# Construction Drawings (PlansProfiles)\_v1.pdf Markup Summary

## 8-29-2022

Cursory comments

STORM DRAIN LINE A - PLAN

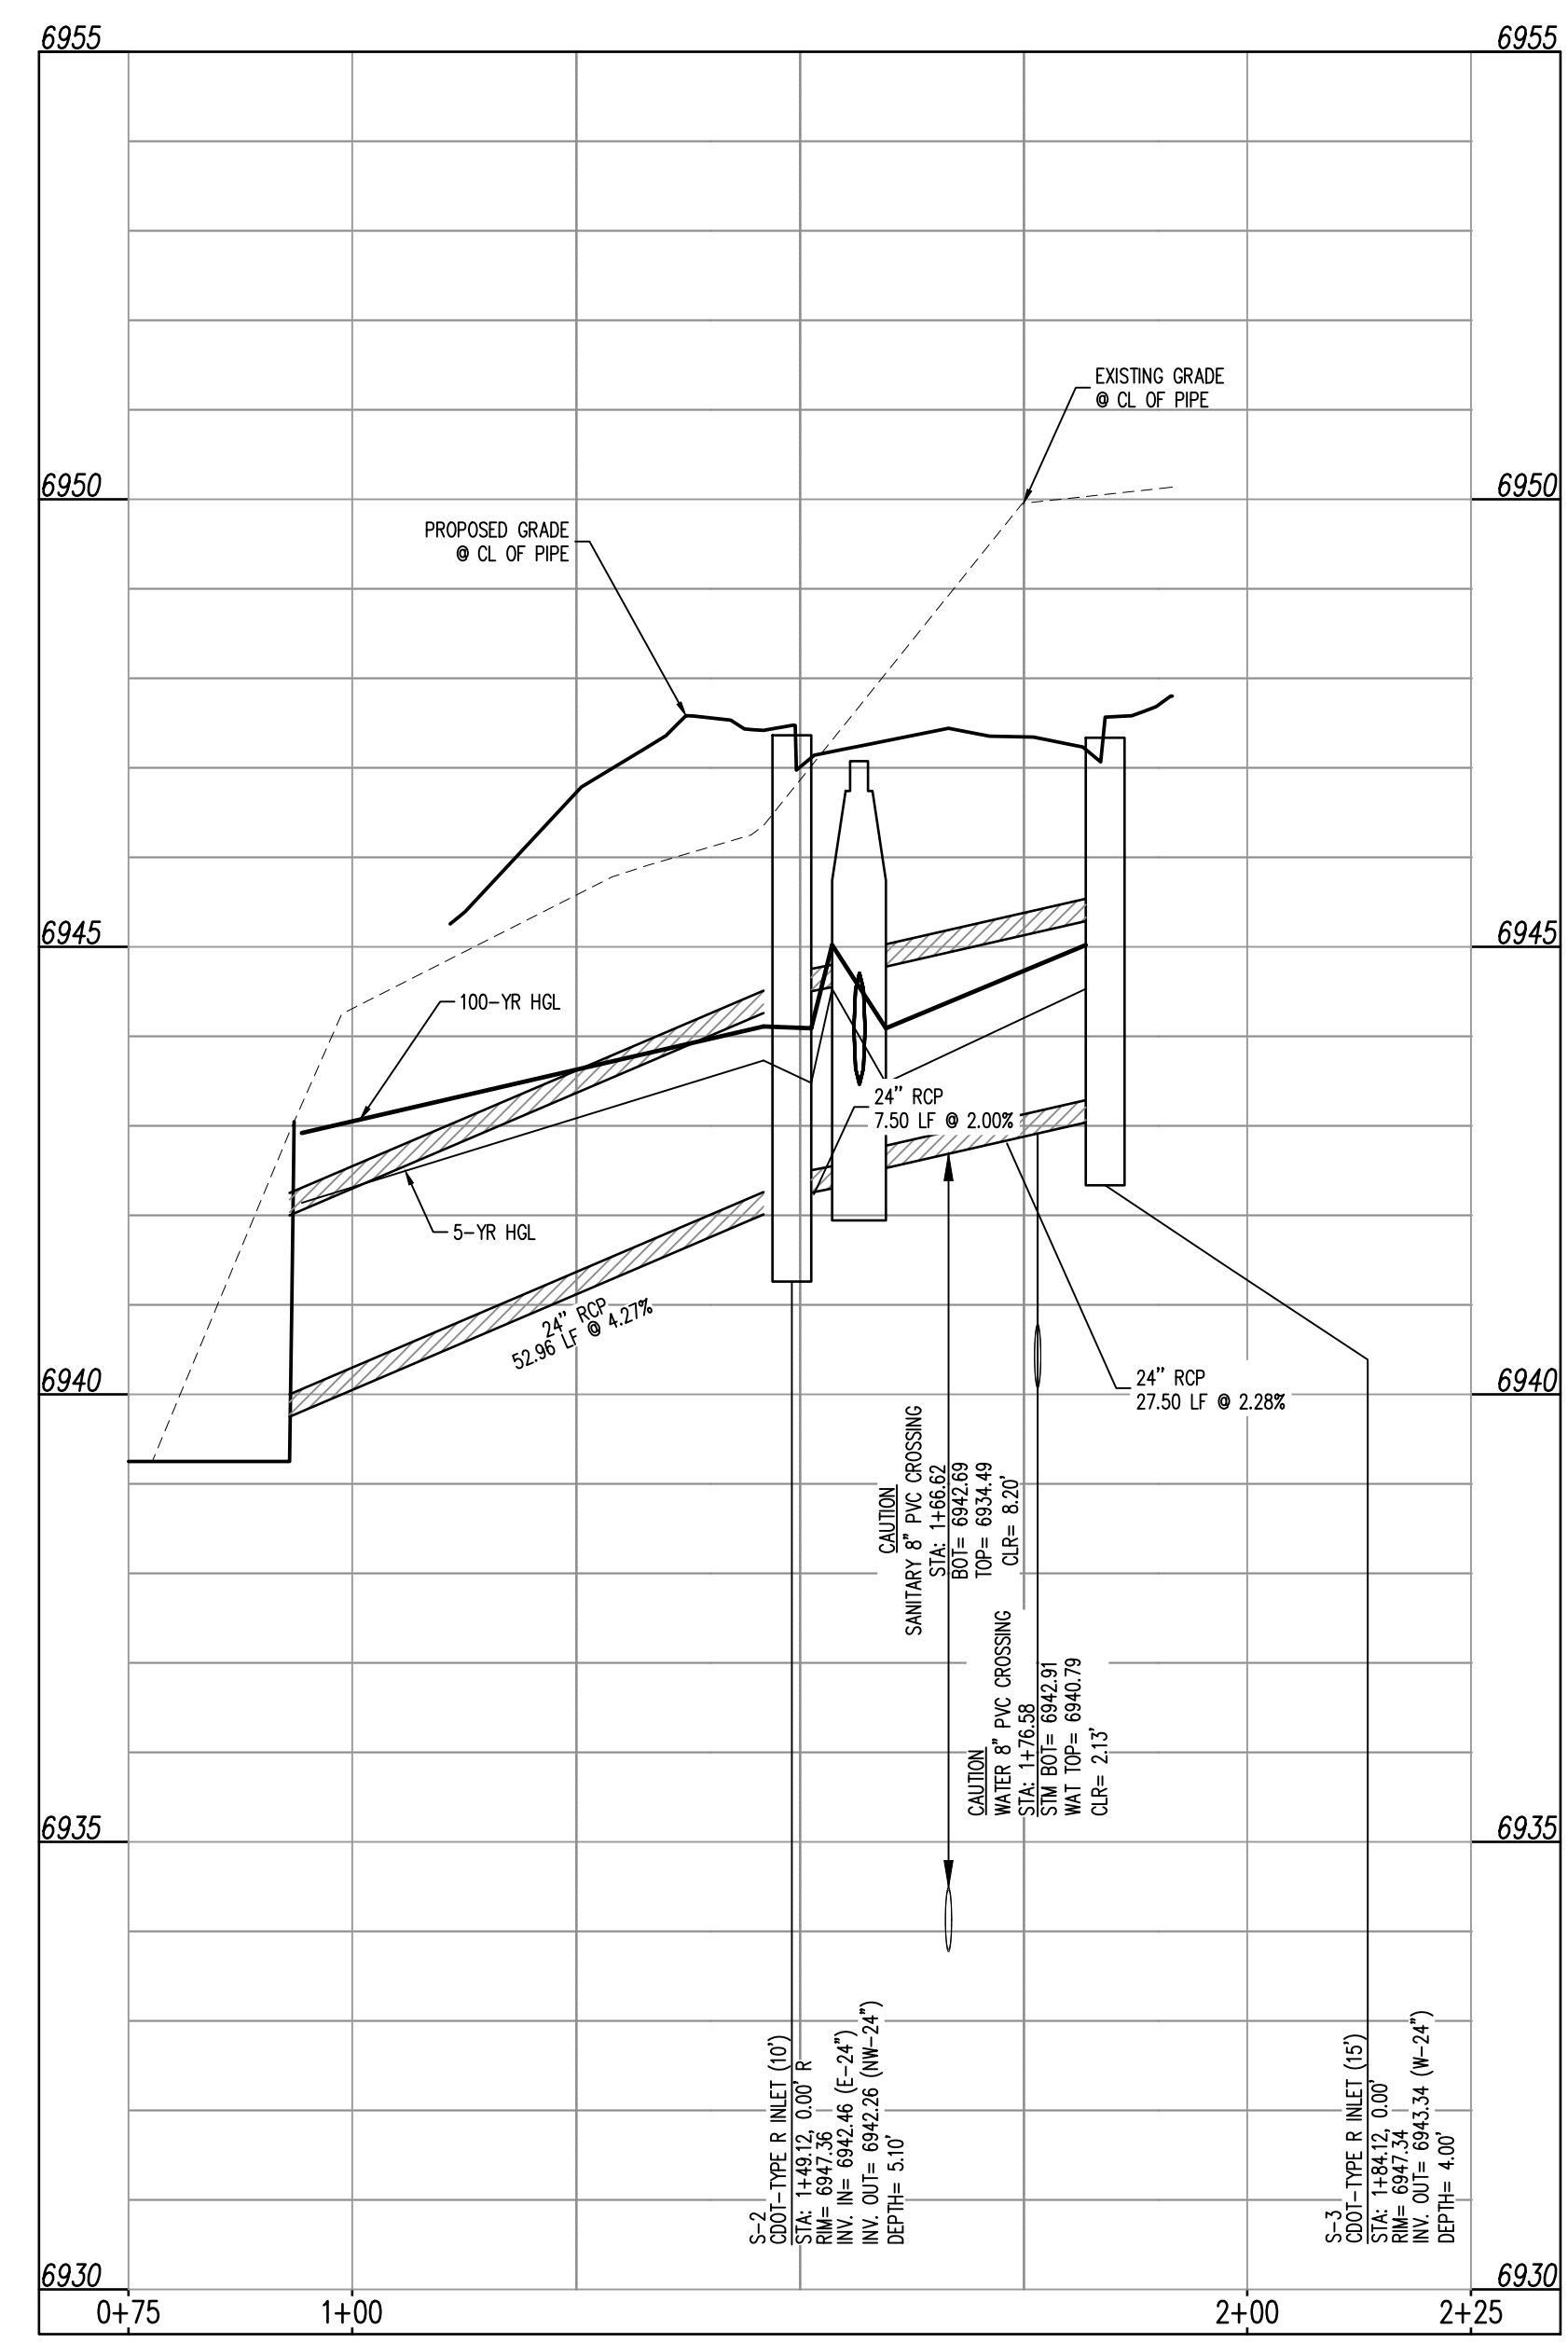
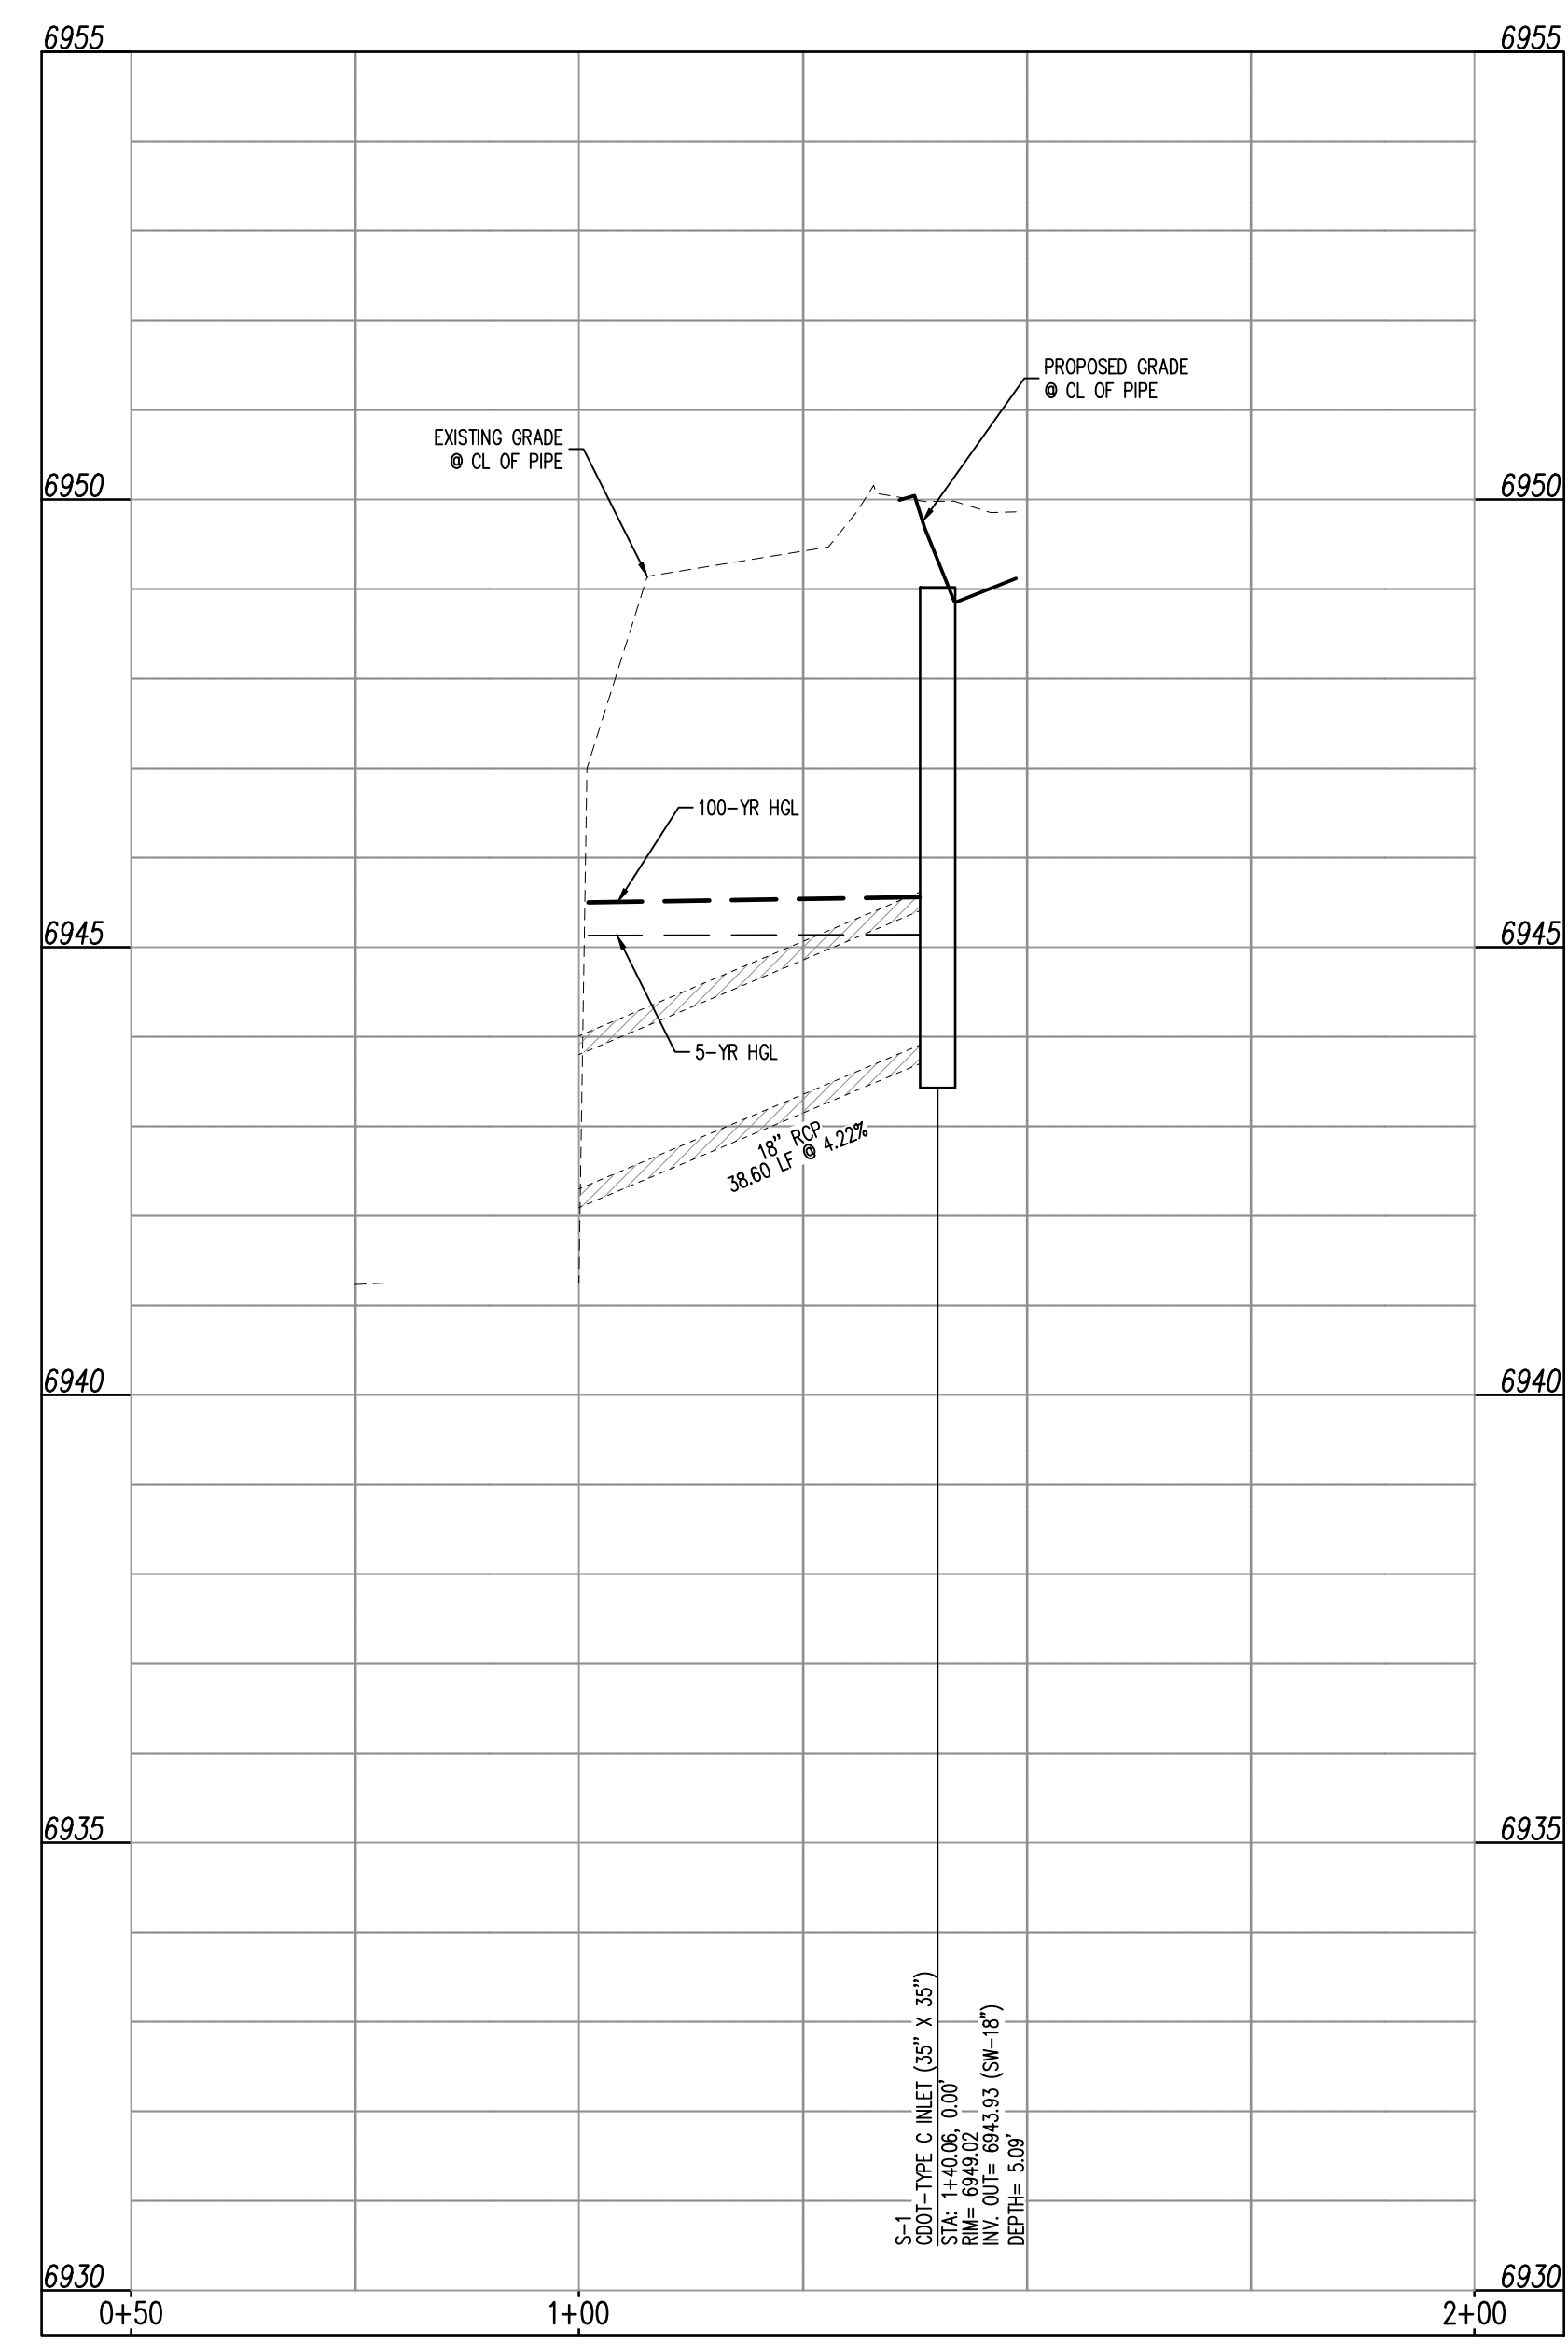
**Subject:** Callout  
**Page Label:** [8] 8 STORM DRAIN PLAN & PROFILE Show and label HGL and Q5 and Q100  
**Author:** dsdrice  
**Date:** 8/19/2022 1:38:30 PM  
**Status:**  
**Color:** ■  
**Layer:**  
**Space:**

**Subject:** Callout  
**Page Label:** [8] 8 STORM DRAIN PLAN & PROFILE Show forebay  
**Author:** dsdrice  
**Date:** 8/19/2022 1:39:14 PM  
**Status:**  
**Color:** ■  
**Layer:**  
**Space:**

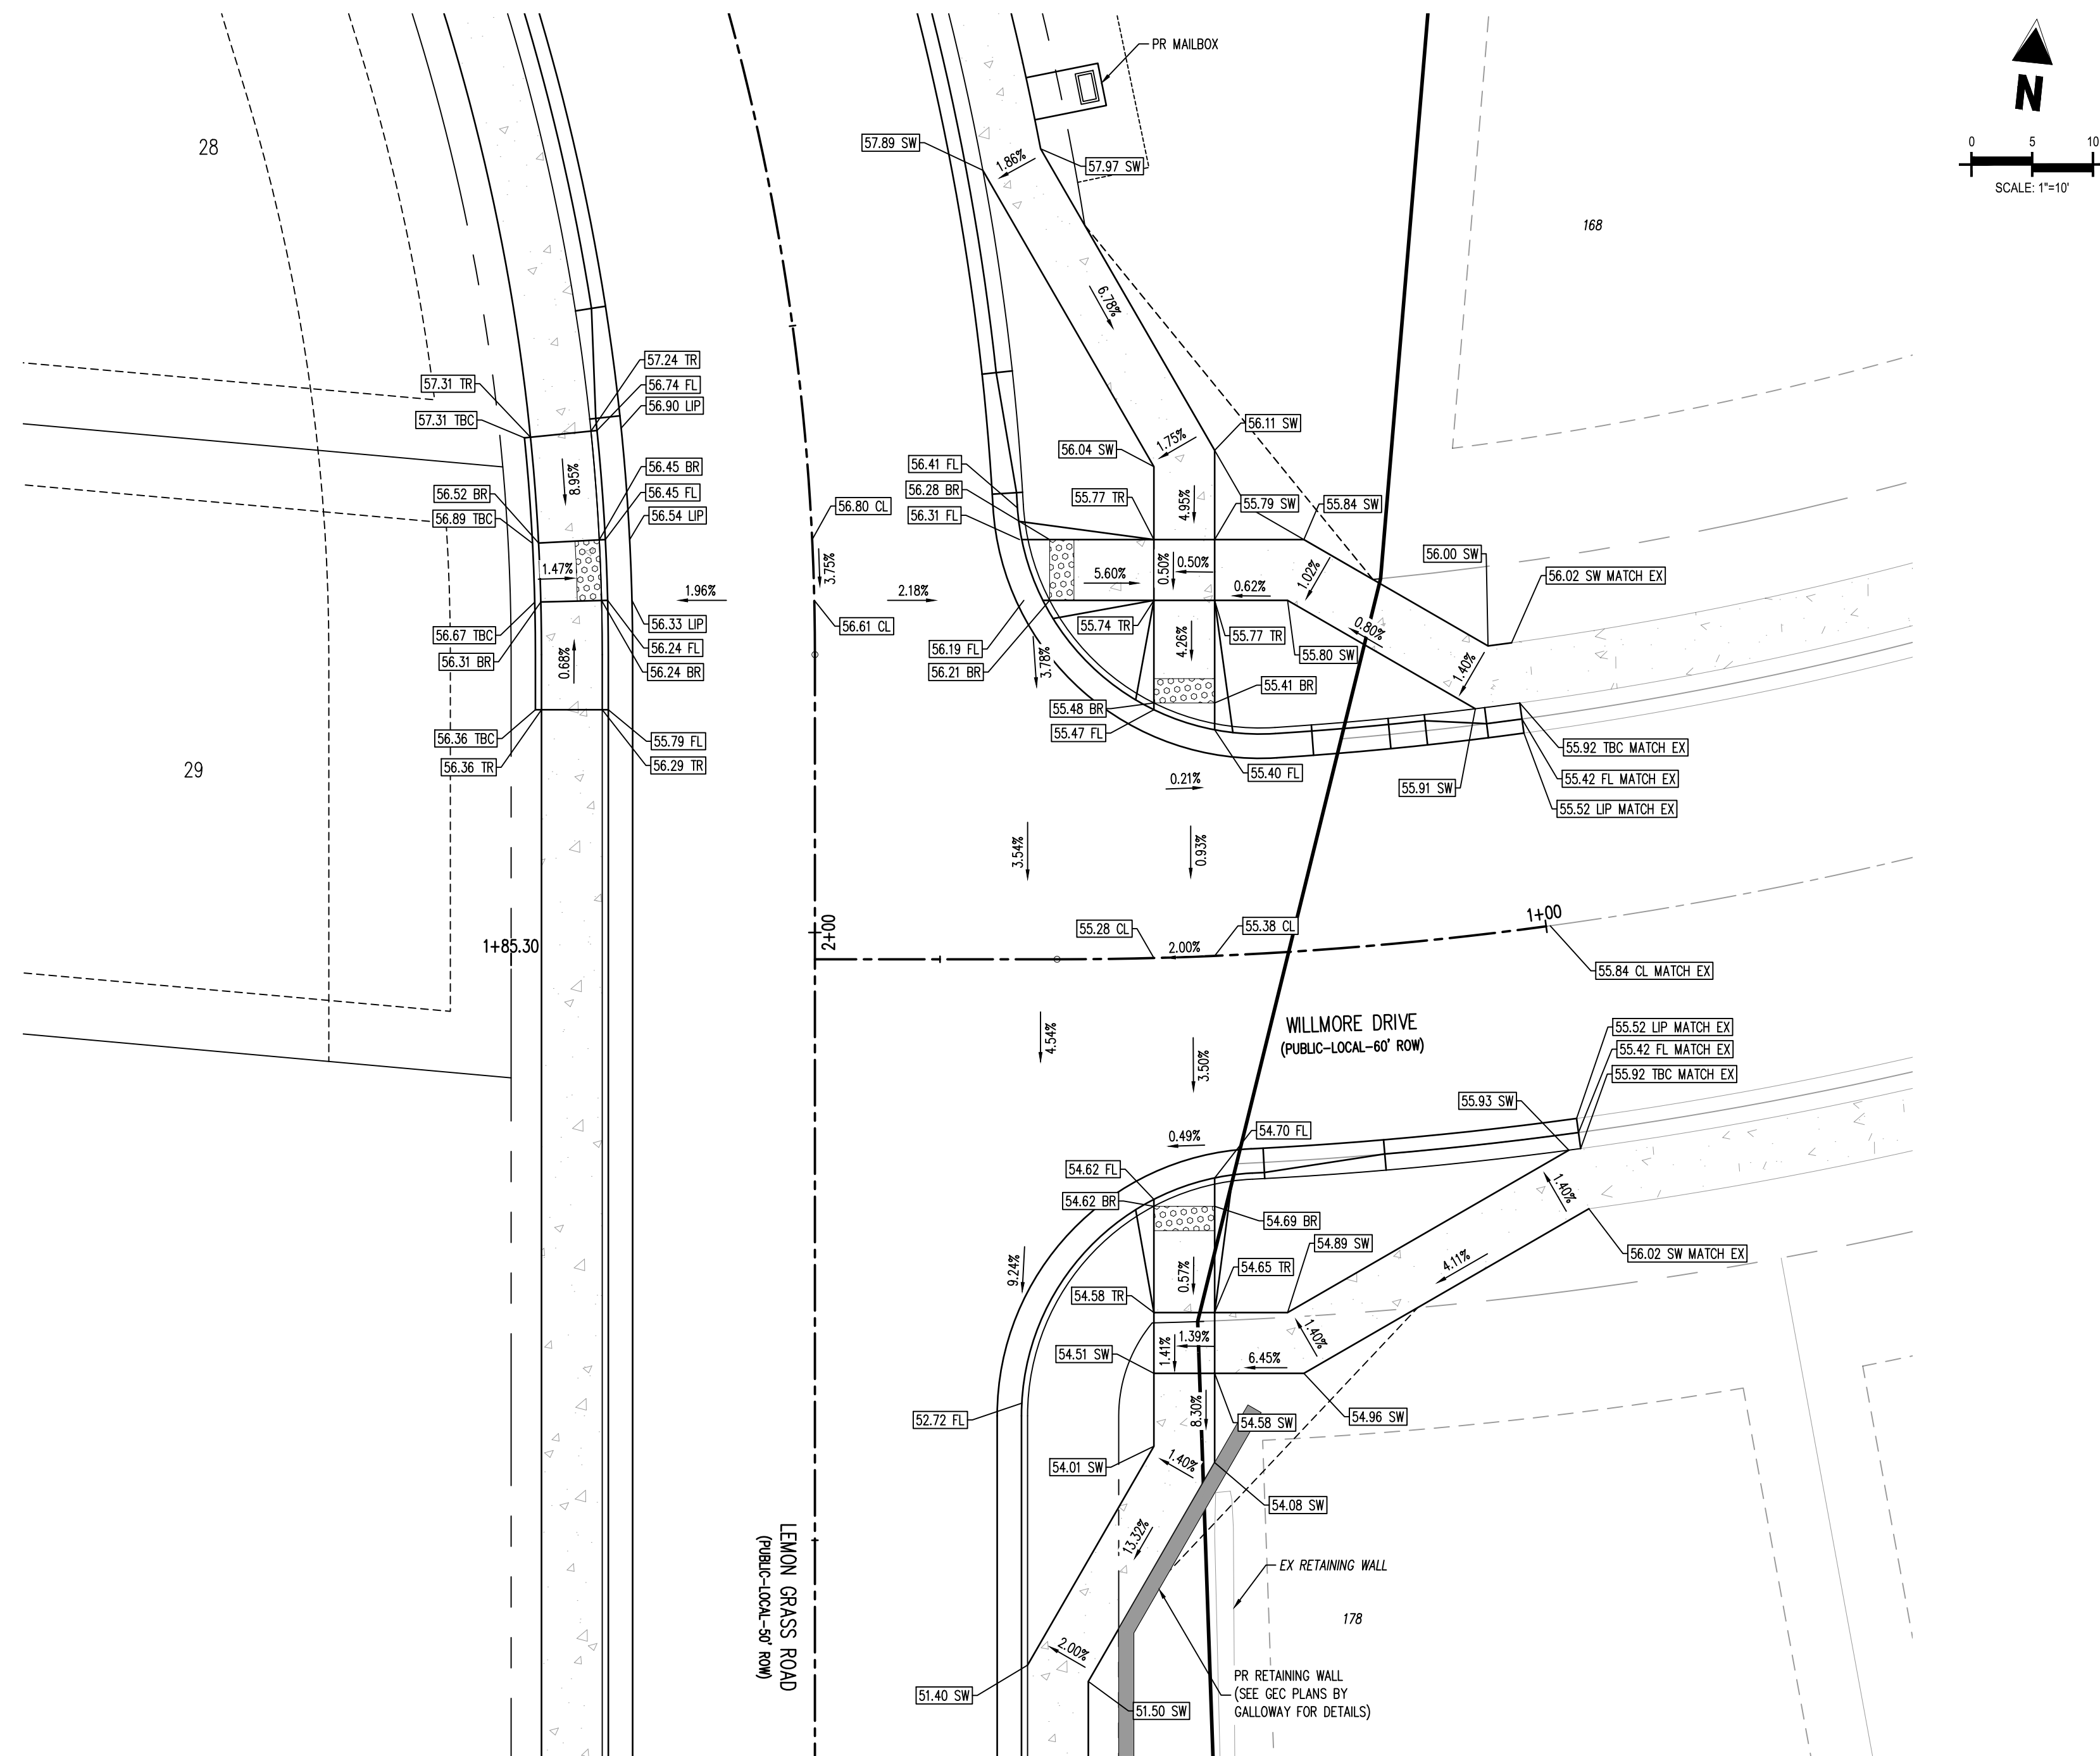
Stop sign?
